Planning Application 2024/92031

Spen Valley Civic Society wishes to comment on the above application for 23 houses on Headlands Works site, Headlands Rd Liversedge. We appreciate that the comment period has ended – apologies but we don't have a meeting in August, so were unable to discuss it until our September meeting.

**MWA DRAWING NO. RSHR-MWA-XX-XX-DR-A-  
0003\_PROPOSED SITE LAYOUT (REV P8) SHOWING MINE  
SHAFT POSITIONS**

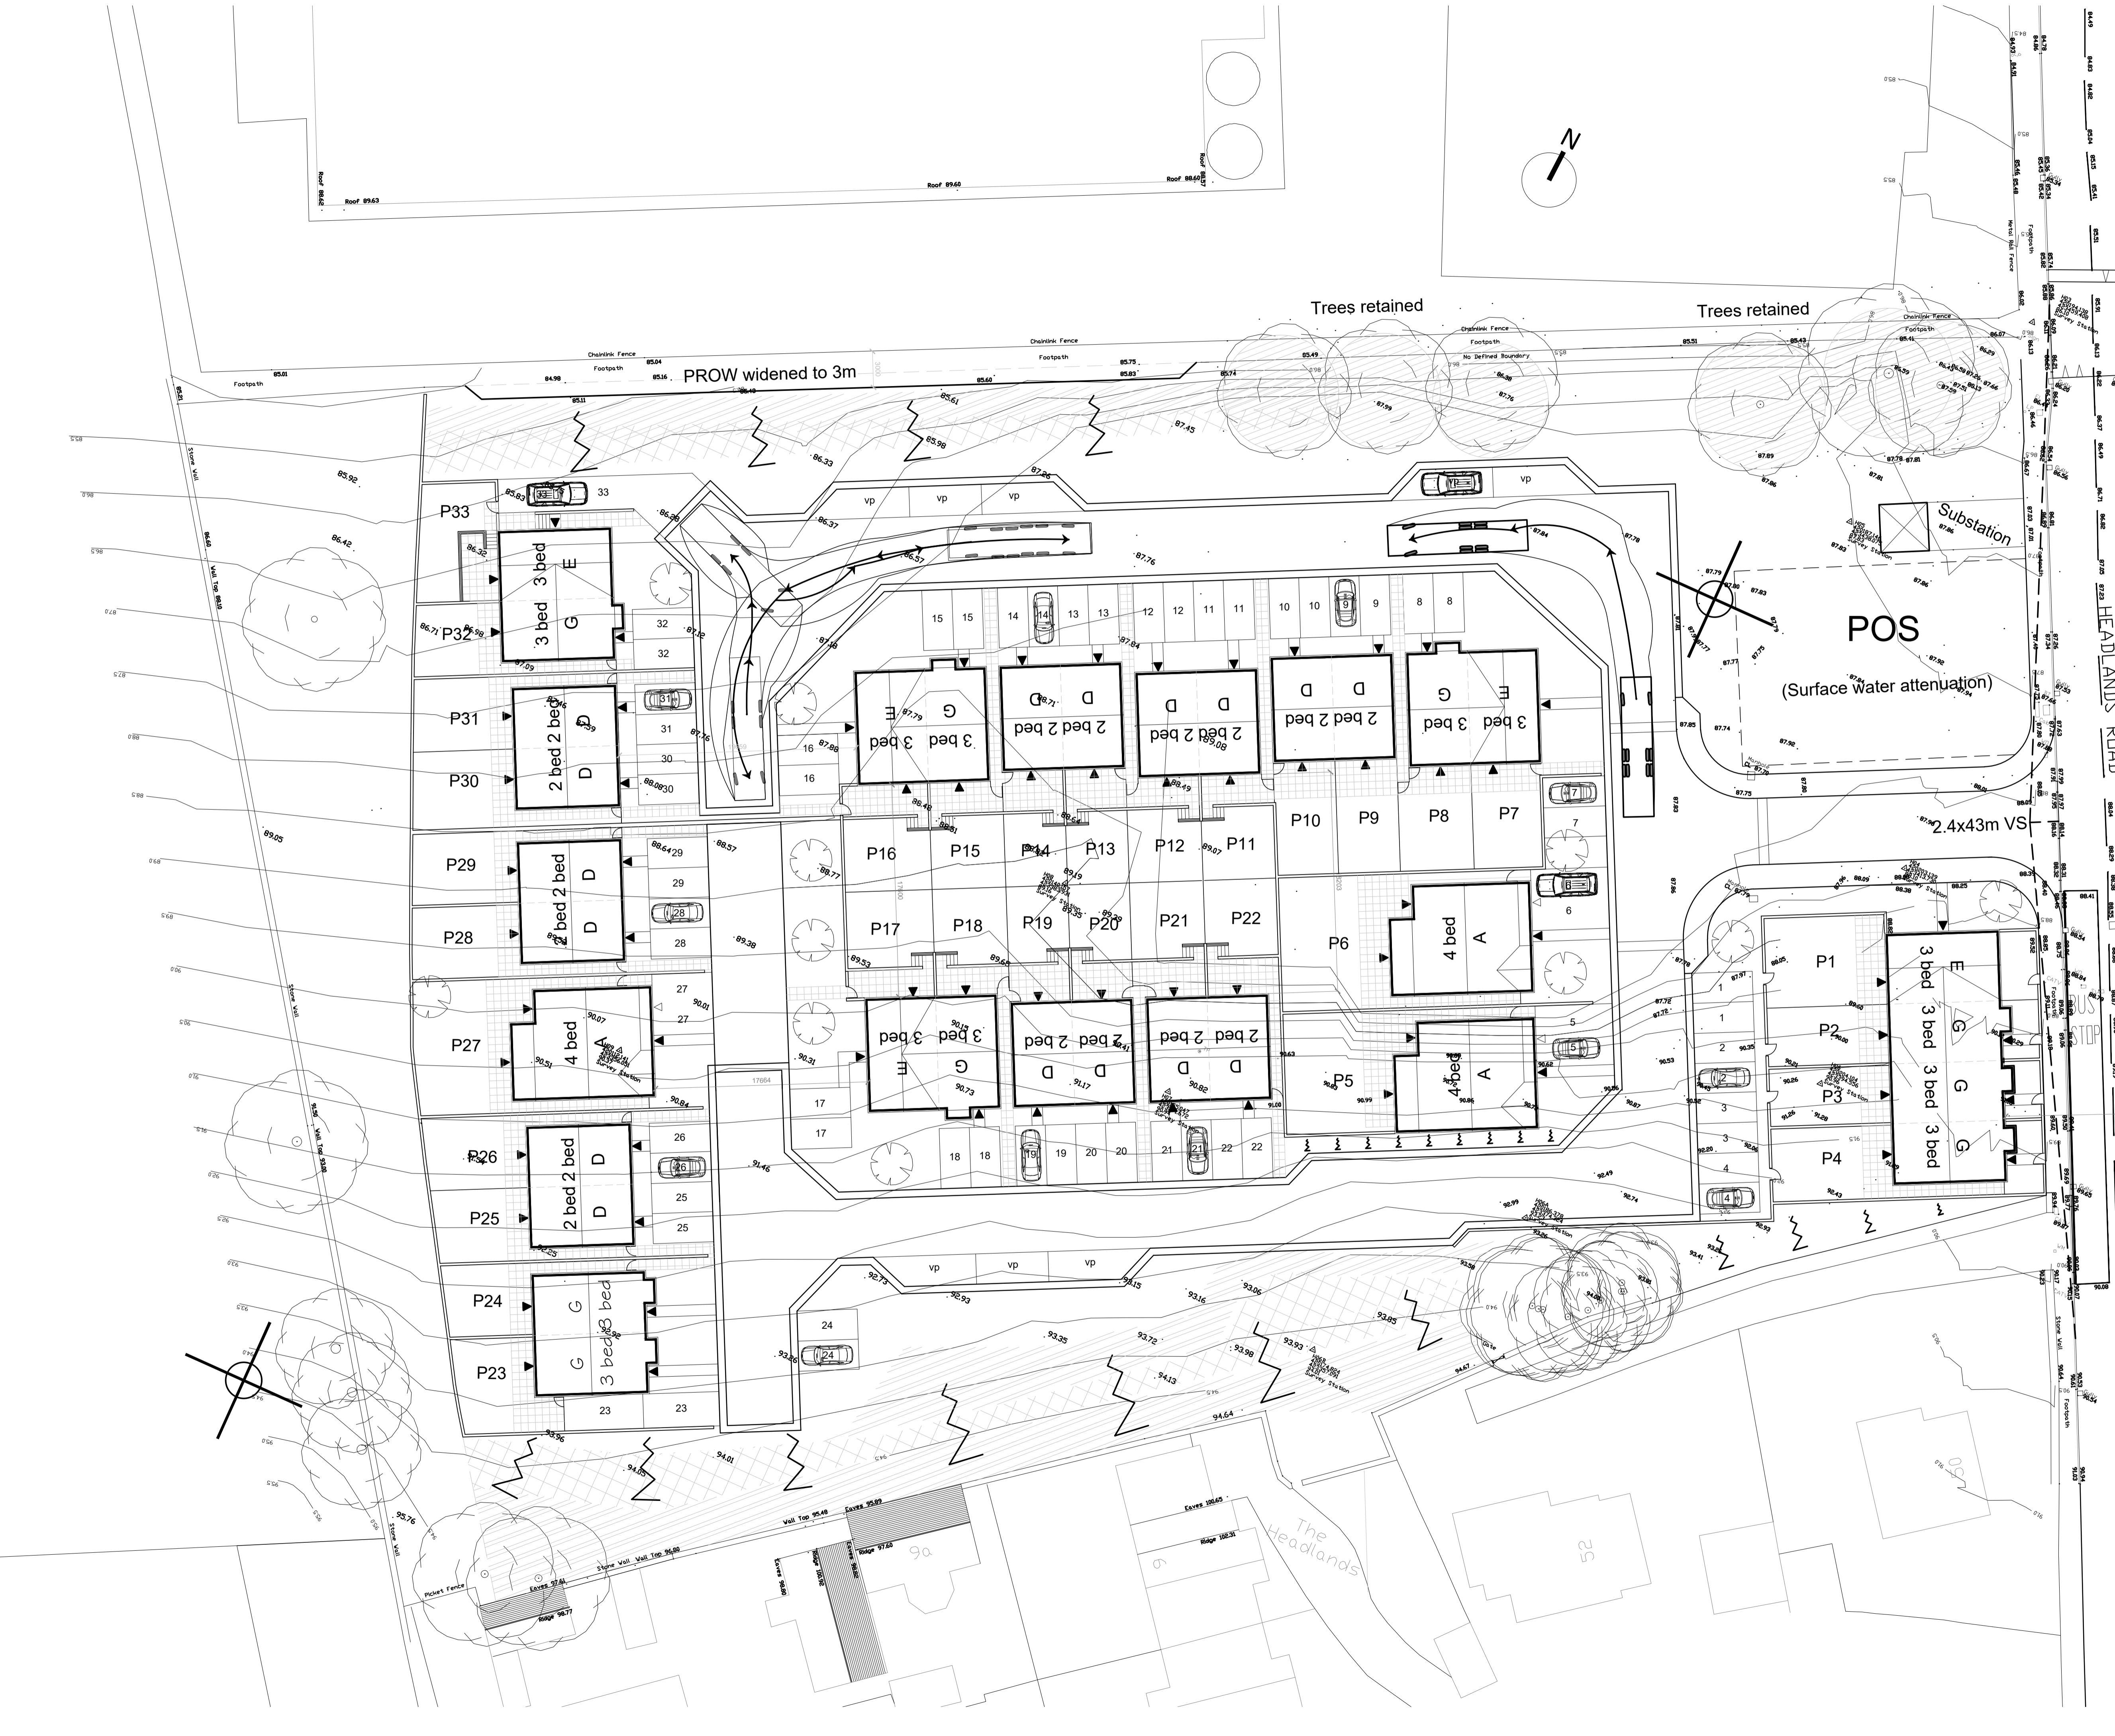
1. We support the NPPF presumption of development but note that this extra housing will result in loss of an employment site.
2. It is important to safeguard footpath SPE 111a/10 that runs along the length of the site. It serves as a pedestrian route to Spen Valley High School for young people resident in Liversedge and Littleton, avoiding the busy A62 and Roberttown Lane junction, and also as a short cut towards Roberttown.

3. There seem to be few trees proposed in the development. Please can loss of biodiversity be checked as the current overgrown site probably provides a lot of habitat.

4. The current frontage to Headlands Road is an old drystone wall and hawthorn trees. It would be respectful of local heritage if some stone walling can be built into the design instead of the unsightly 2m tall wooden fences often seen around new housing. A similar small housing development in Hartshead (pp ref 2019/92670) has received praise from local people due to the characterful stone walling provided by the developer.

5. Given the small scale of this development we feel that the housing mix is inappropriate. 15 four-bed houses is 65.5% of the total. We think that local housing need requires fewer 4 bed houses and more two- and three-bedroomed houses.
